City of Albuquerque

March 1, 1982

RE: 612 1st STREET RENOVATION DRAINAGE REPORT

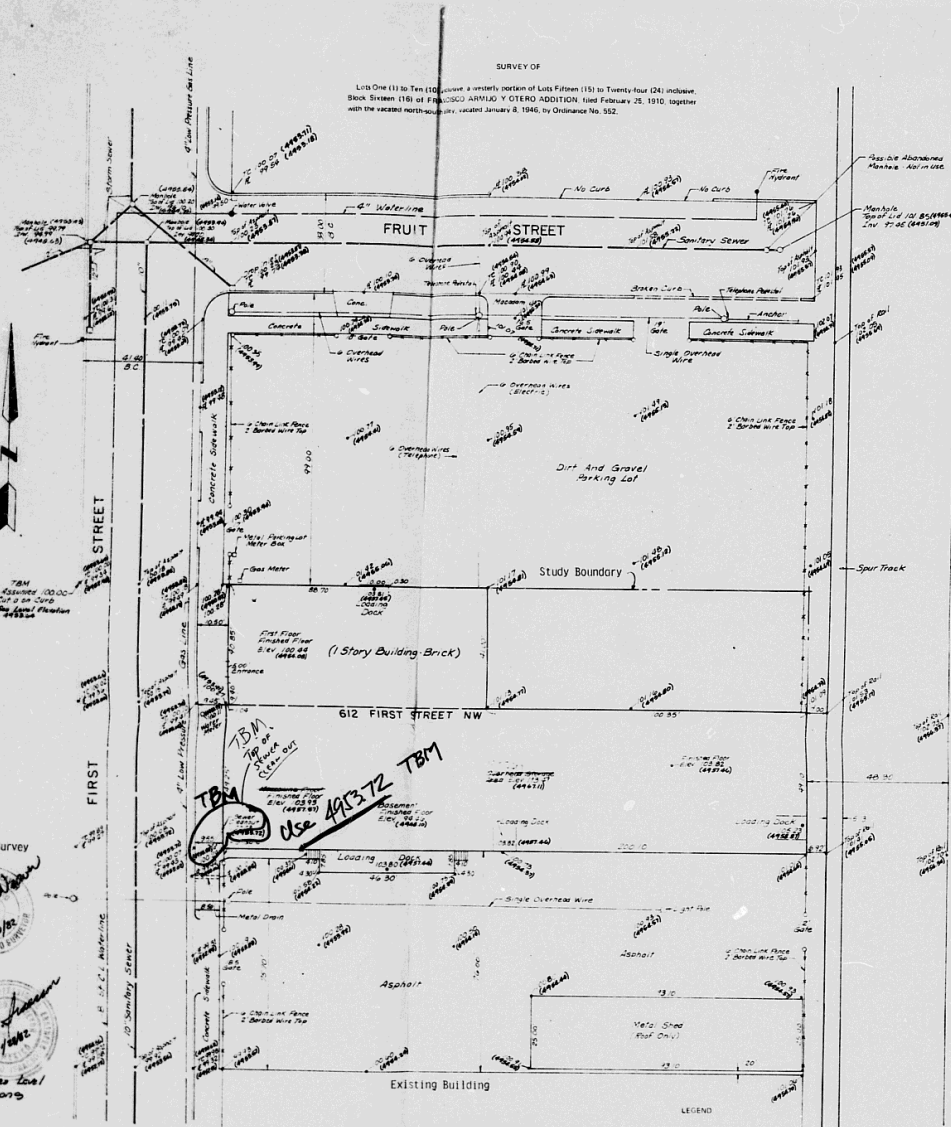
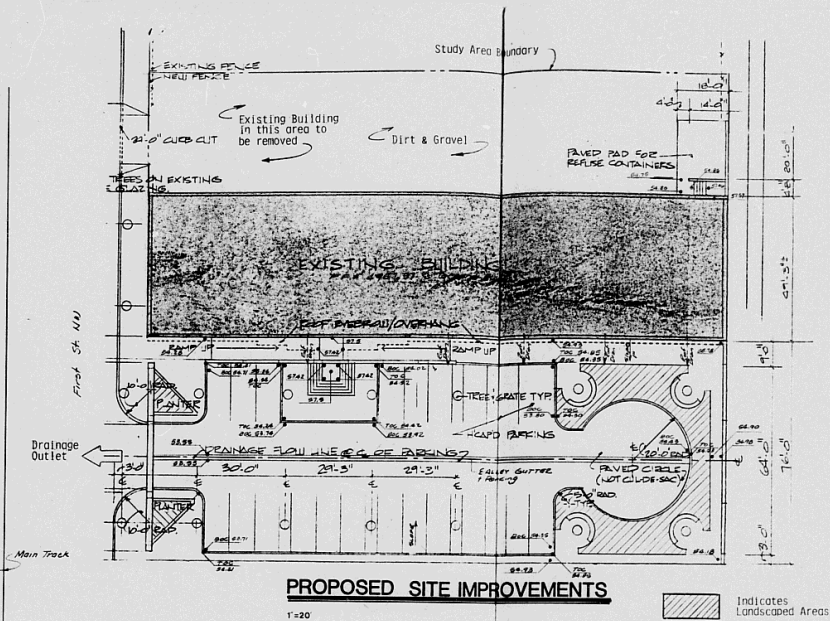
The referenced report is approved. However, we would appreciate you identifying a temporary bench mark on the plans. This is a big help when a survey is made for the Certificate of Occupancy (If you like, just call and I will make the note on our plans).
